From: Paul Cann
Sent: 18 September 2017 13:49
To: Simon Davis

[REDACTED]
Subject: RE: P/49/17/DOC Church Farm Holiday Village [NLP-DMS.FID263510]

Further comments;

DETAIL E - TYPICAL SECTION THROUGH NORTHERN CATCHMENT PERMEABLE BLOCK PAVING INCORPORATING POLYPIPE PERMAVOID SUB-BASE REPLACEMENT ATTENUATION SYSTEM
Scale (1:20)

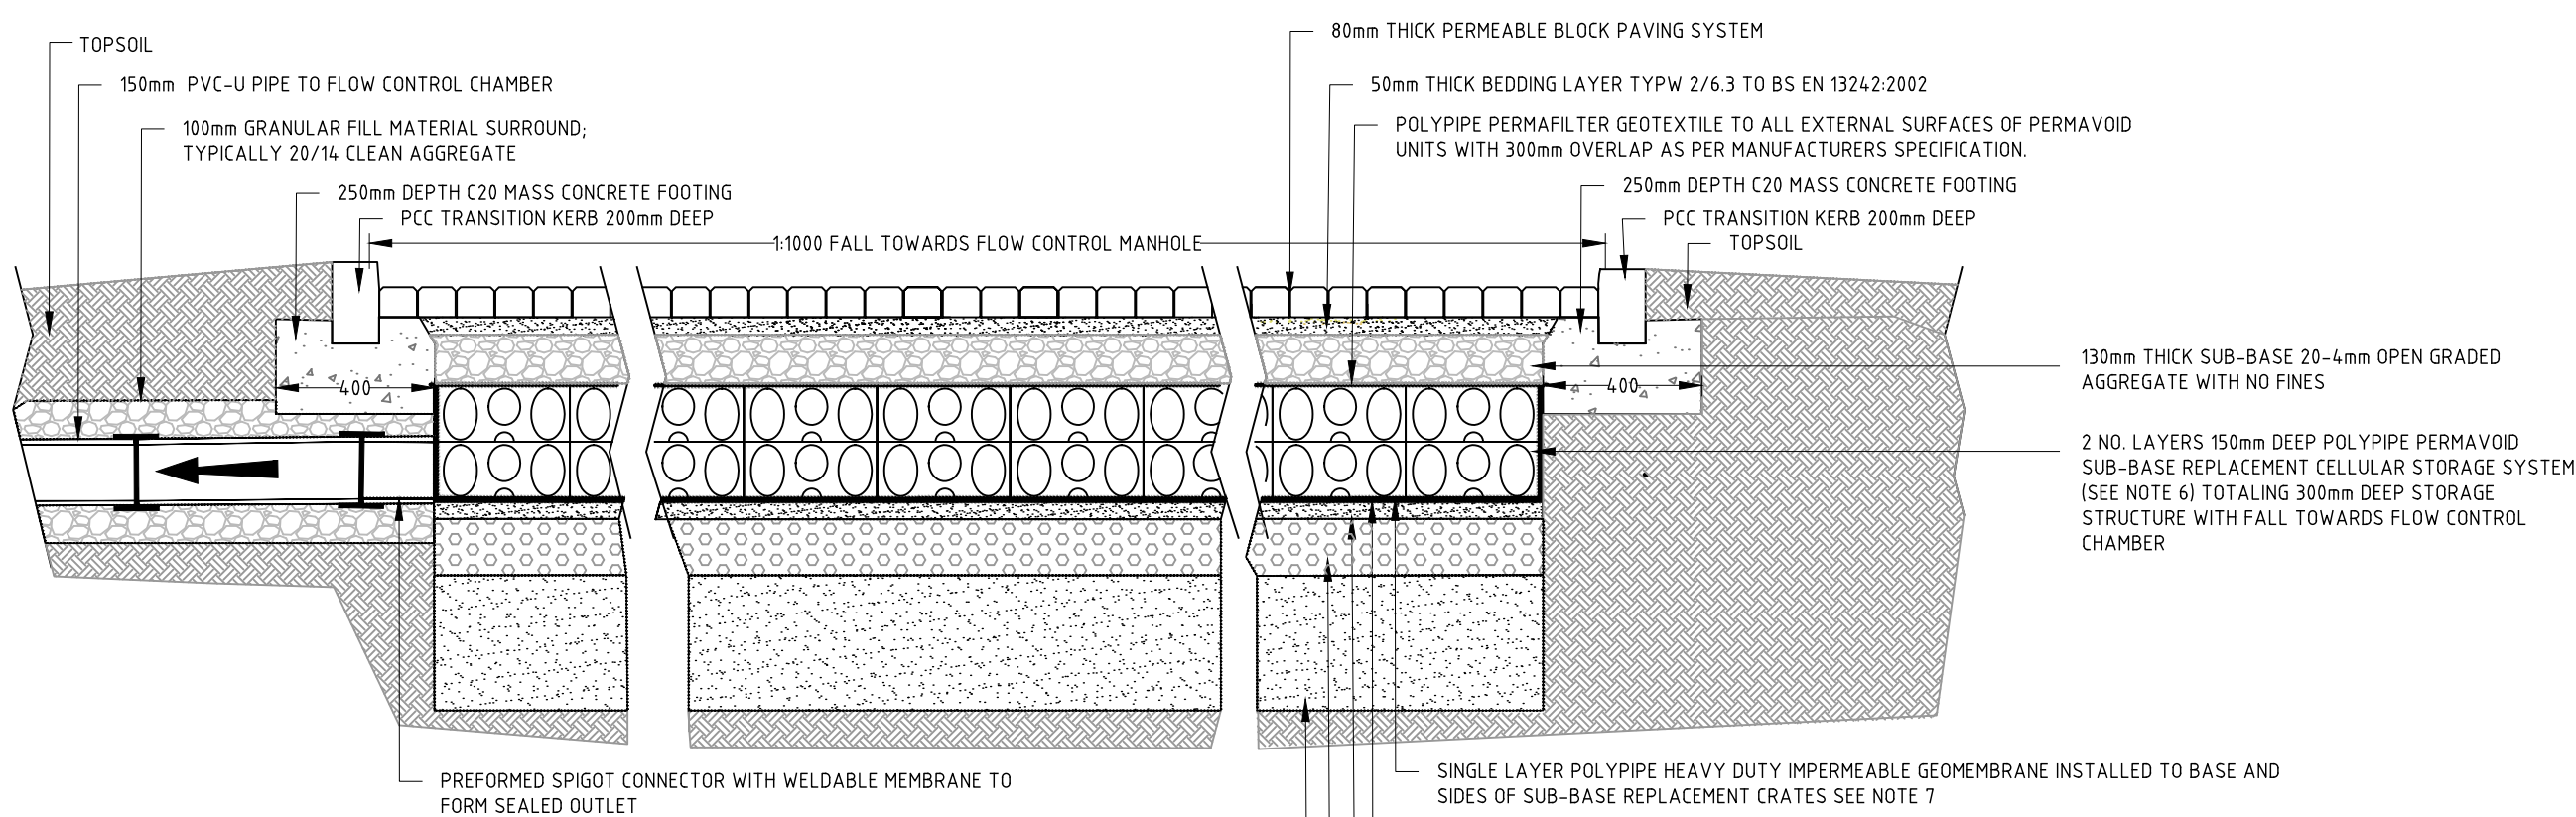
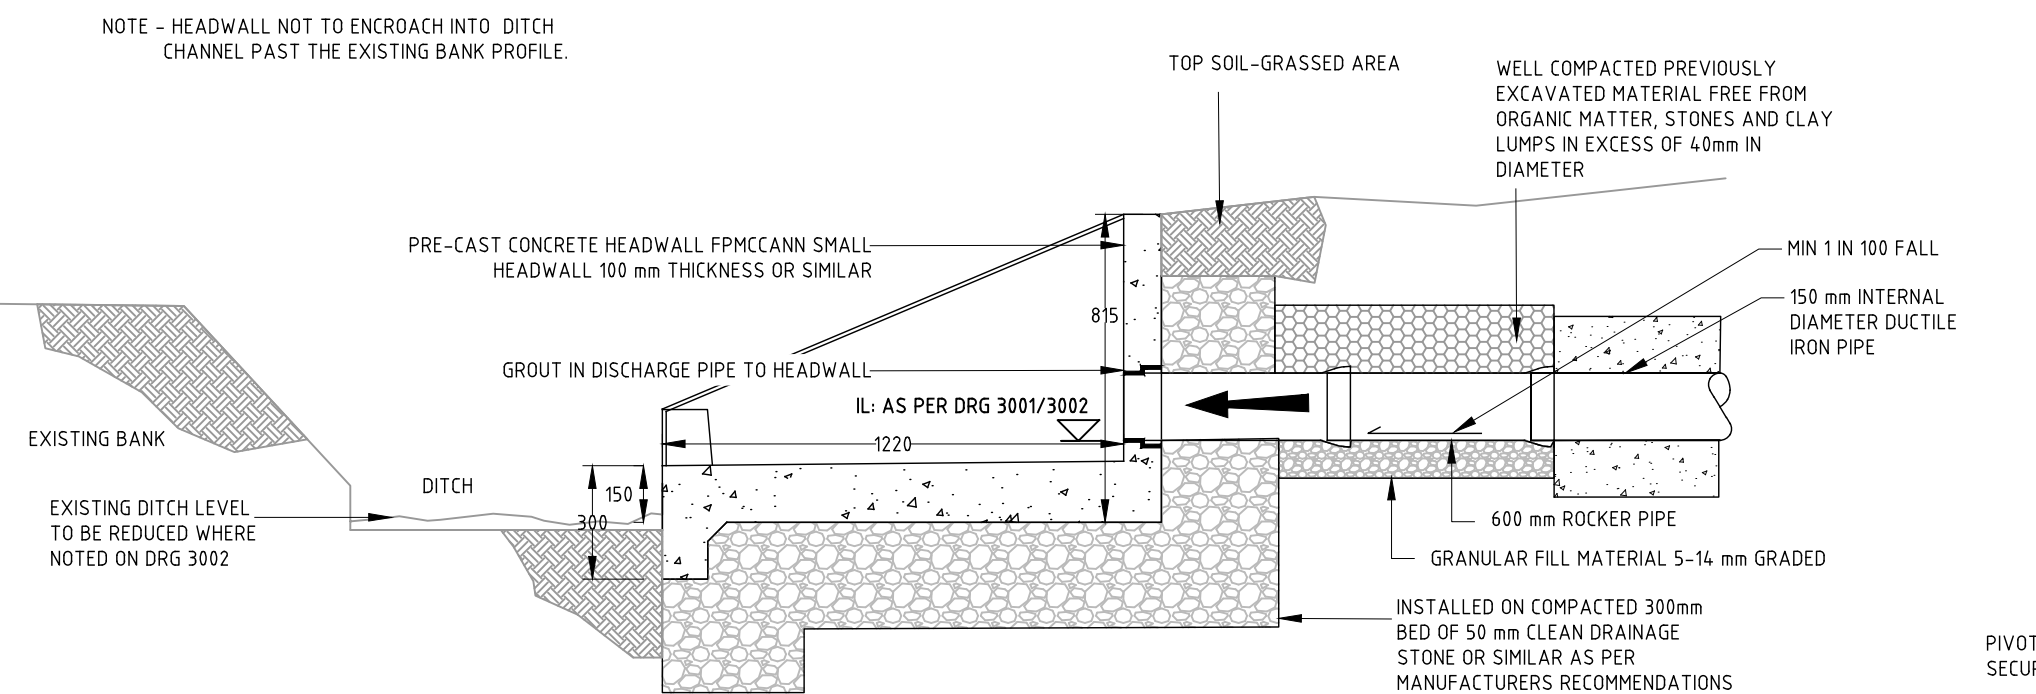
1. They need confirmation from the permavoid crate manufacturer (polypipe) that there will be no detriment to the crates due to the vehicle loadings/minimal cover.
2. The proposed headwall structures must not encroach into the profile of the ditch ie. beyond the existing banks. Add a suitable note to the drawings.
